## KITTTITAS COUNTY COMMUNITY DEVELOPMENT SERVICES

February 12, 2020

Subject: Shoreline Exemption Permit (SX-20-00001) - Request for Additional Information

STREISSGUTH PROPERTY  
 13270 N. THORP HIGHWAY  
 THORP, WA 98946  
 TAX PARCELS 579133 & 591736 - 4.57 AC

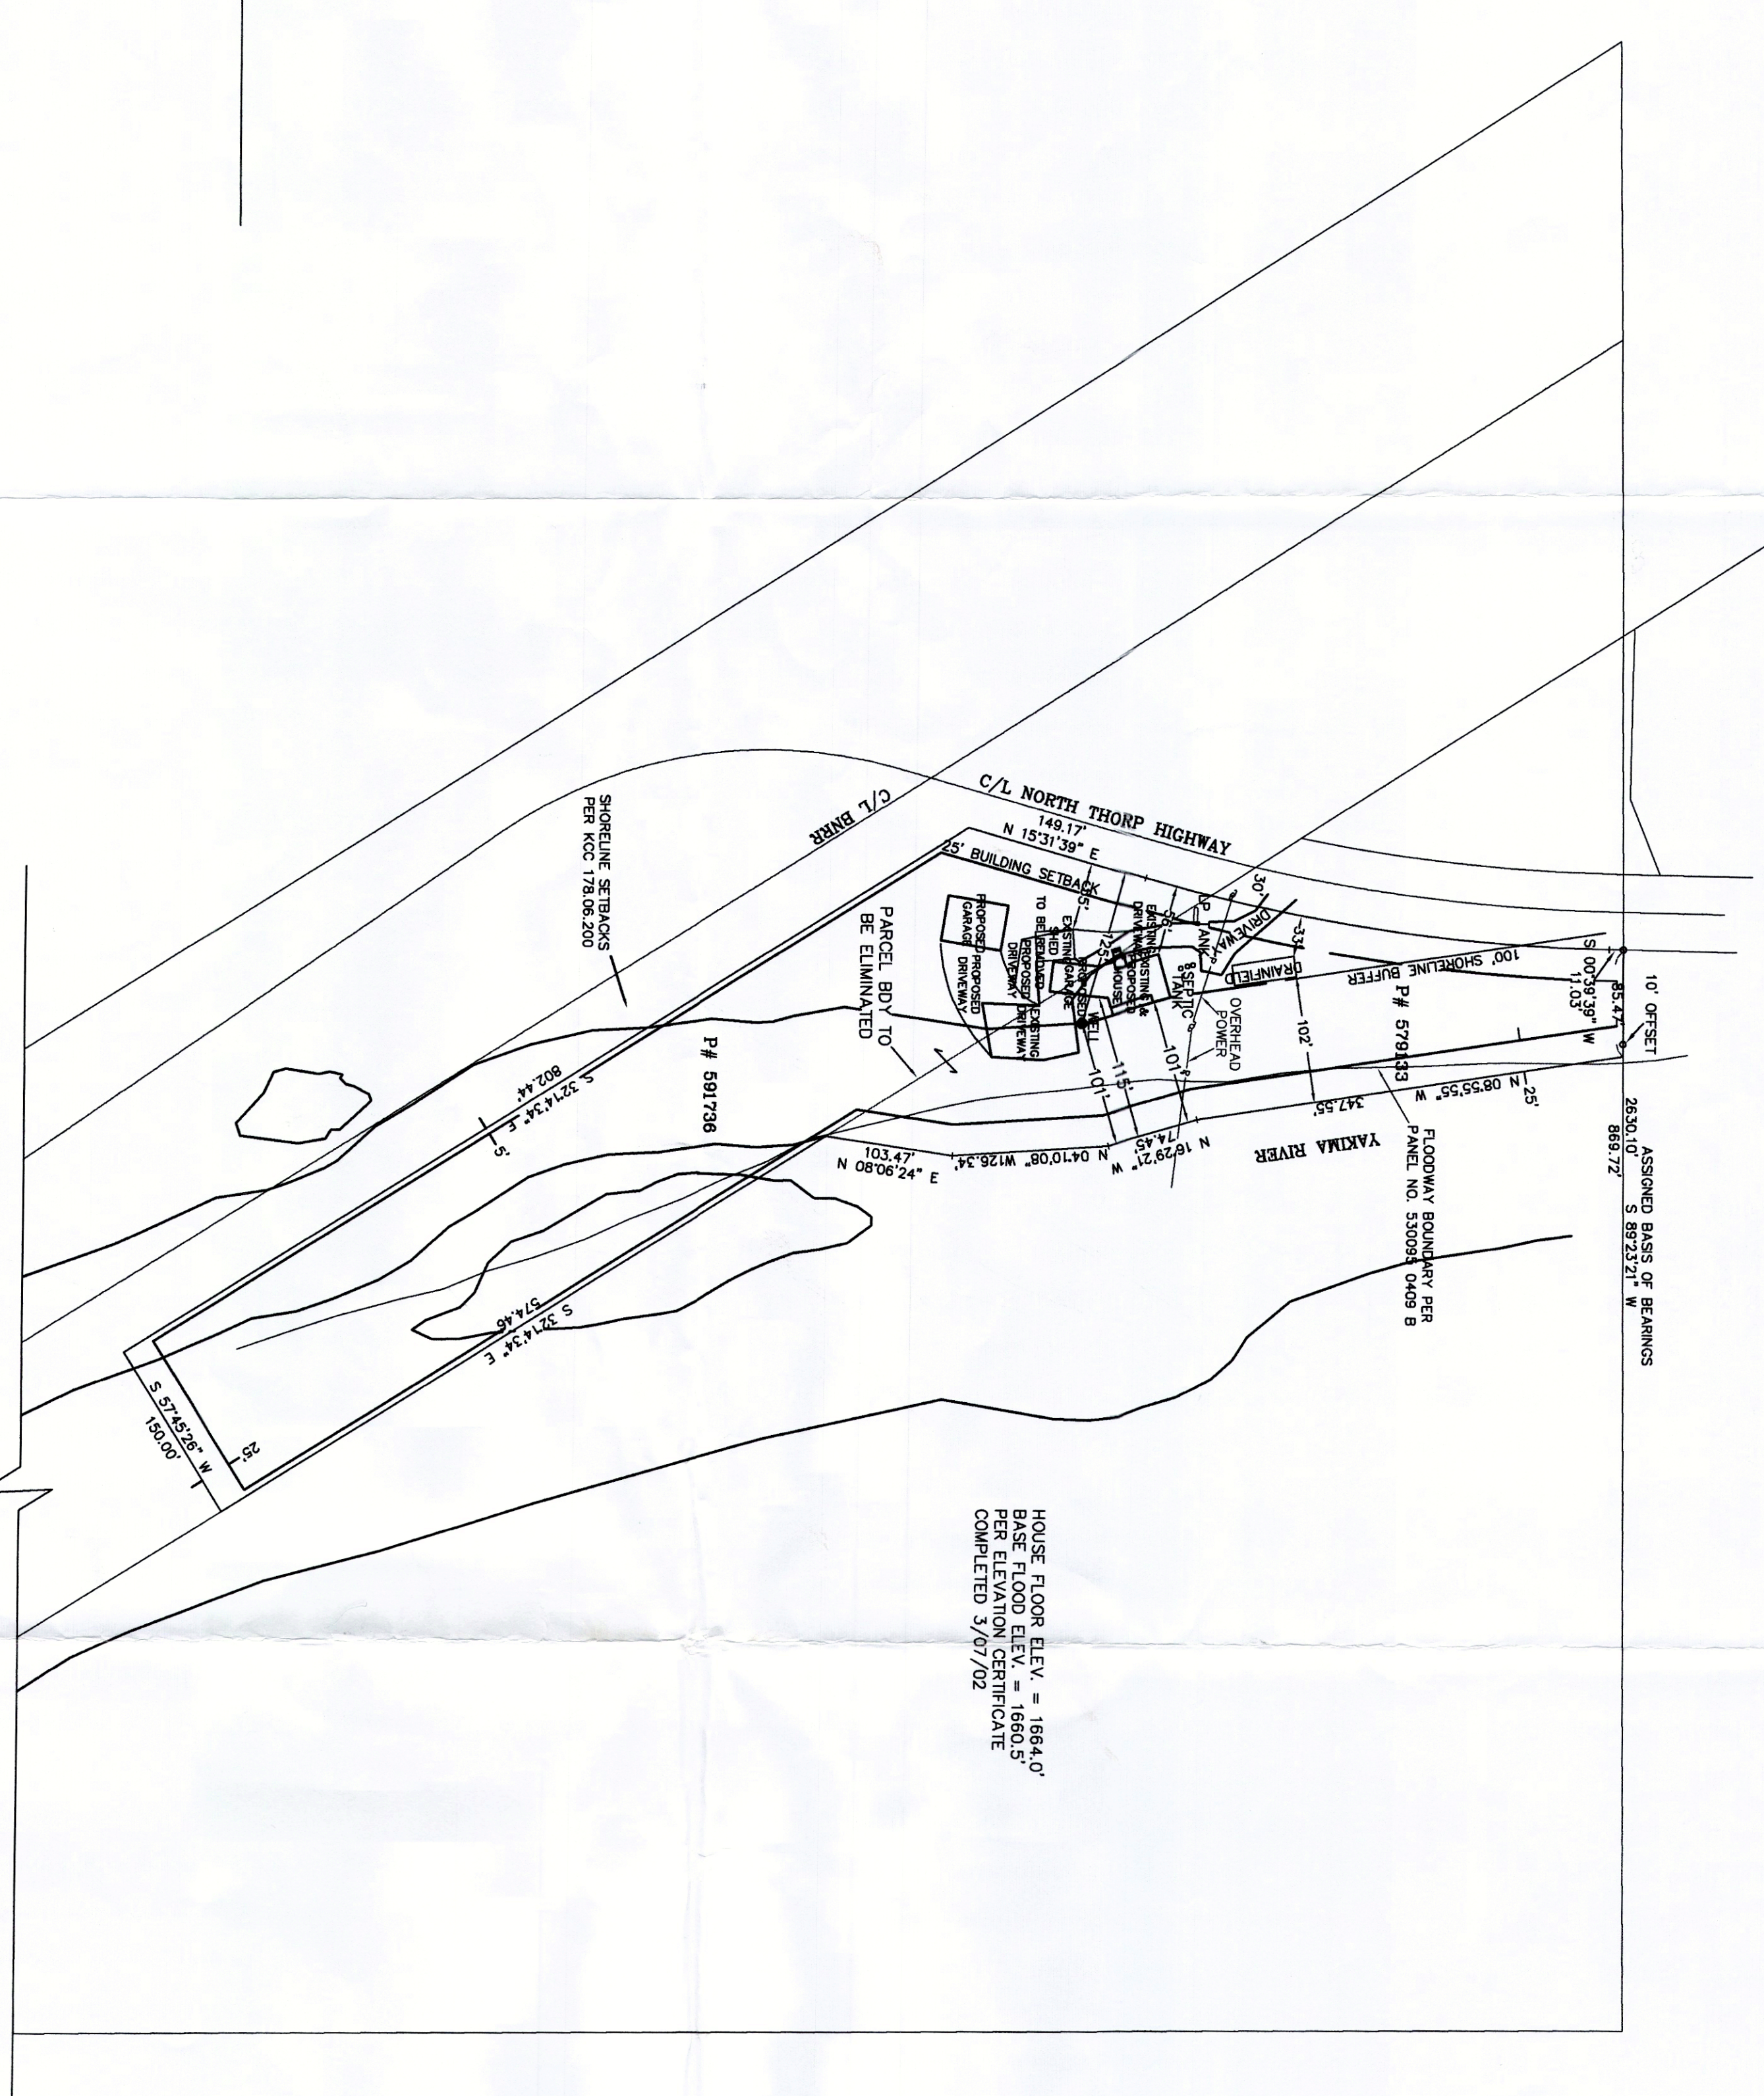
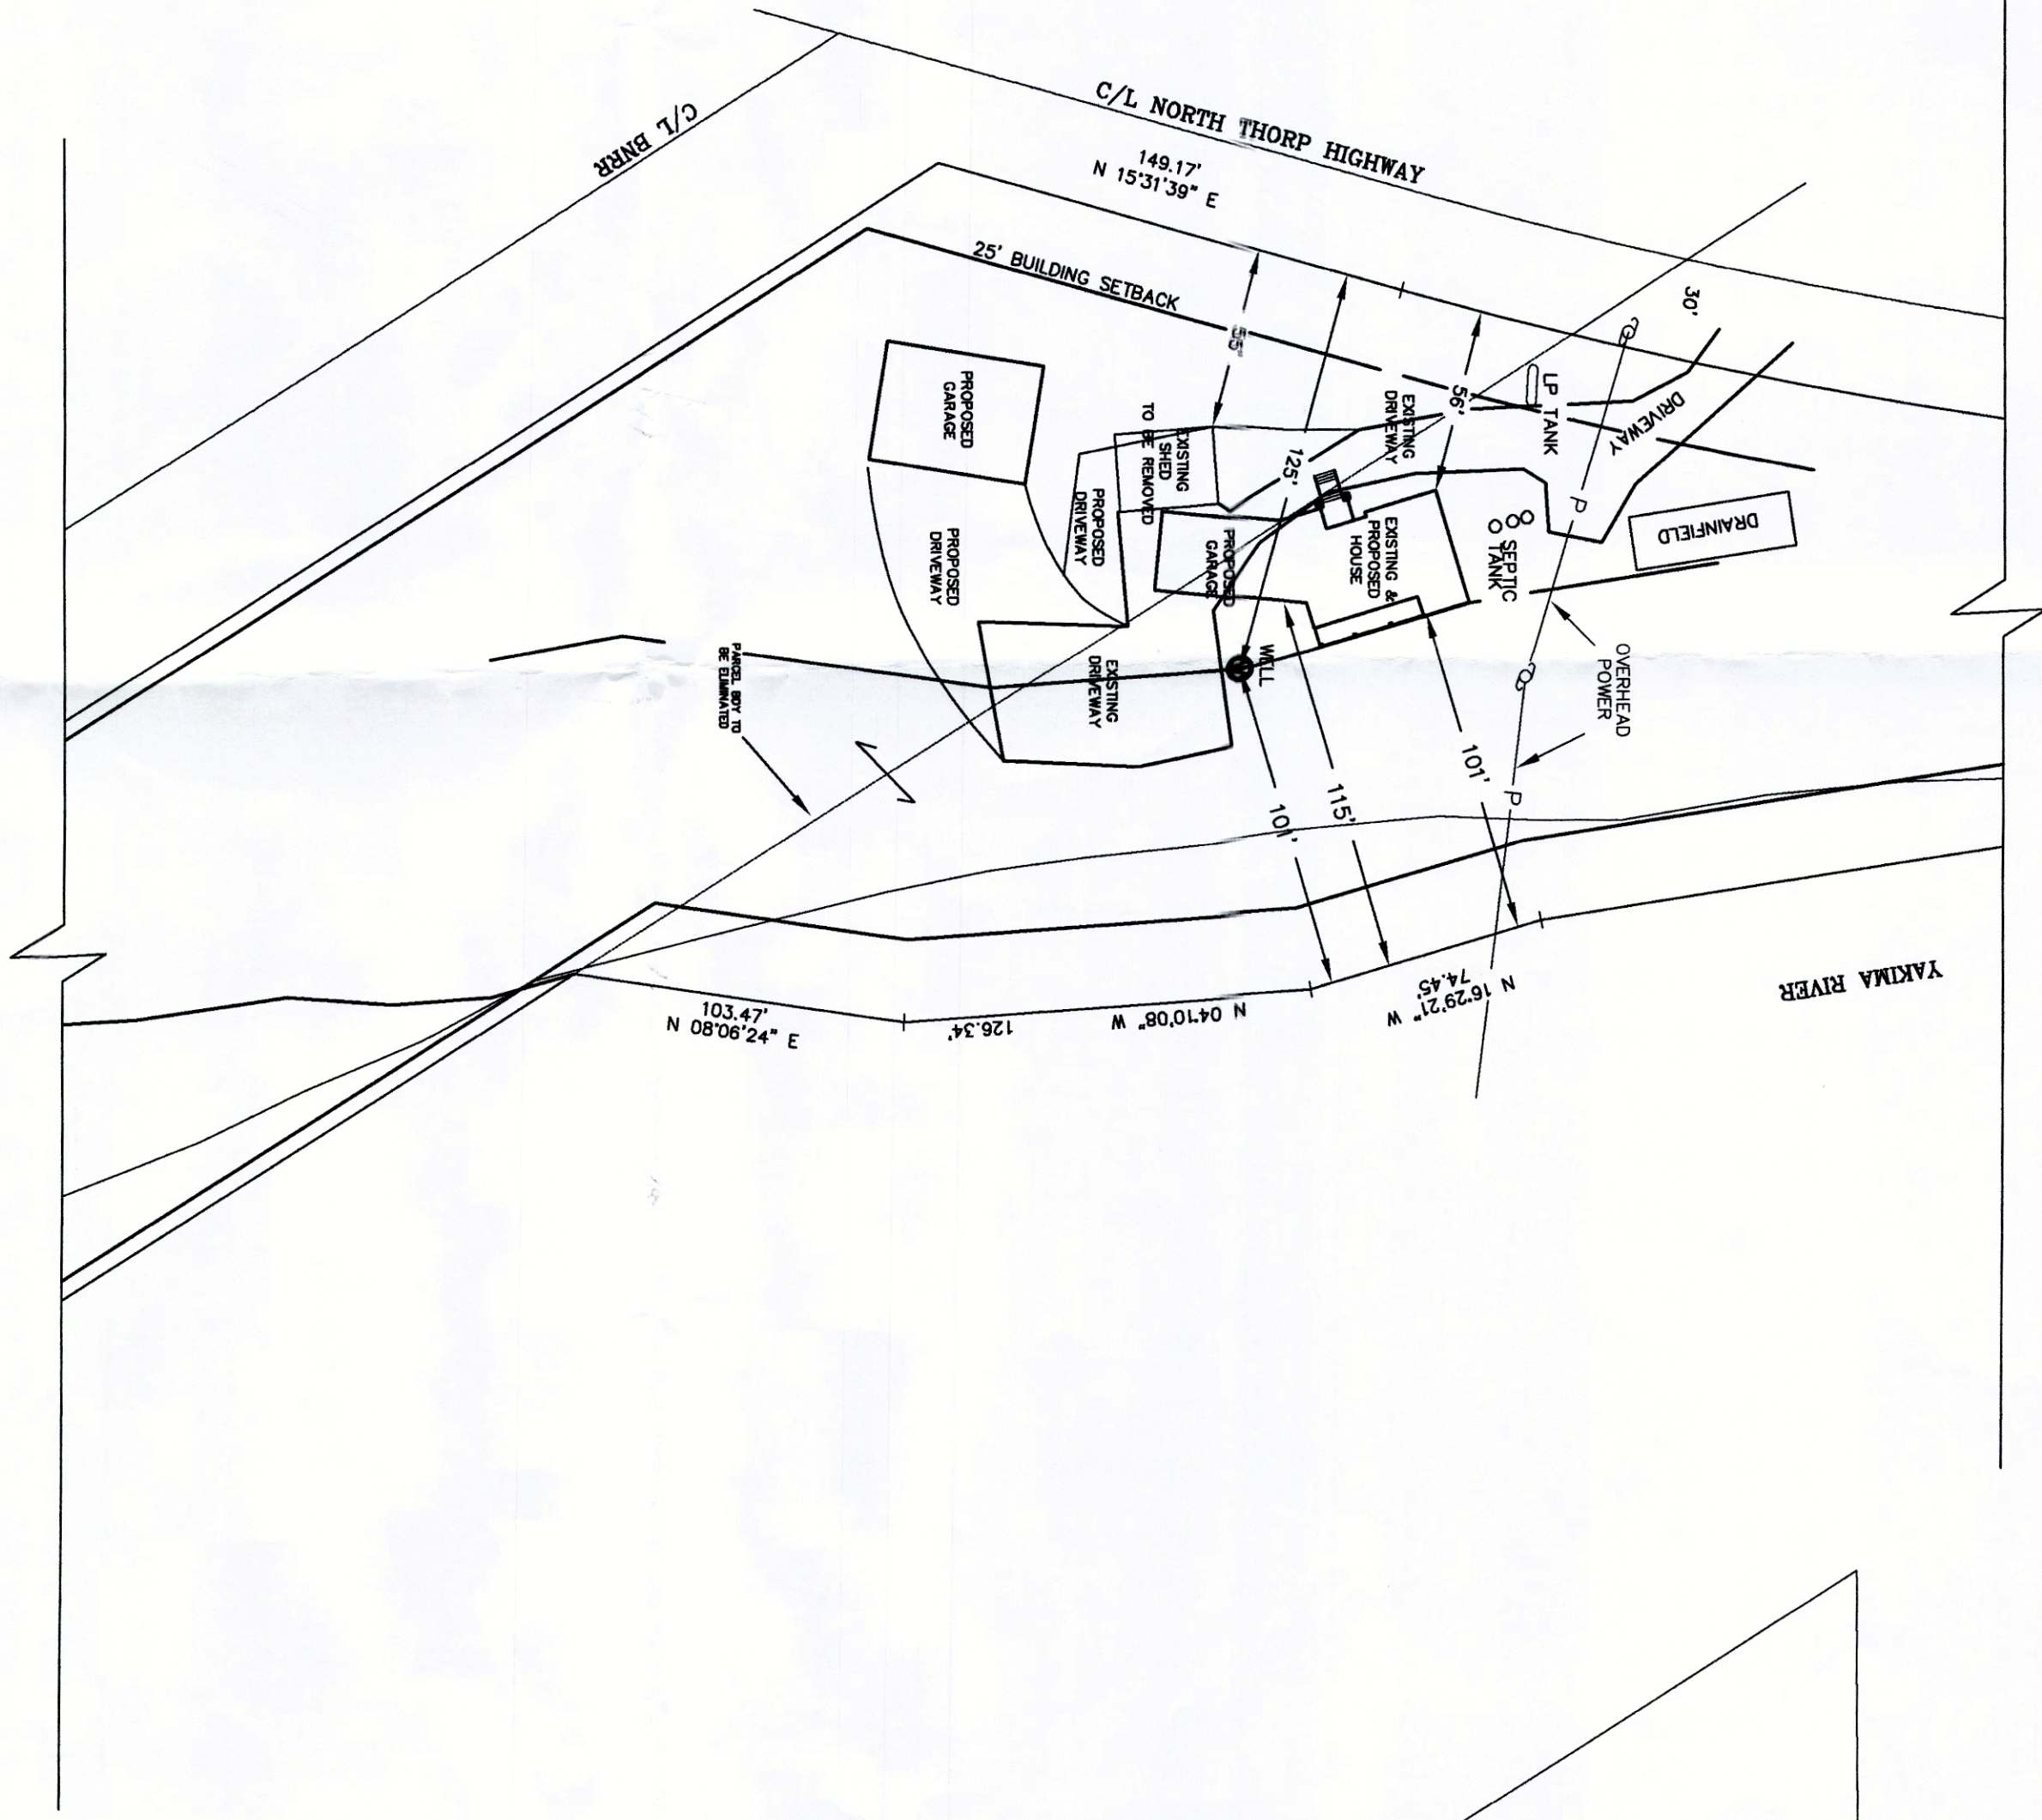
1. Updated site plan showing the following:
  - a. Clearly identified Ordinary High Water Mark (OHWM) of the Yakima River
  - b. Show the distance(s) from the proposed detached garage to the OHWM.
2. A section of the new proposed driveway falls within the 100' buffer. Kittitas County Code 17B.05.020C General regulations for all critical areas (4) allows for driveways to be located within the fifteen (15) foot building setback, but not within the one hundred (100) foot buffer. Please update your site map to show that all new proposed driveways will remain outside the one hundred (100) foot buffer.

Please update your site plan accordingly.
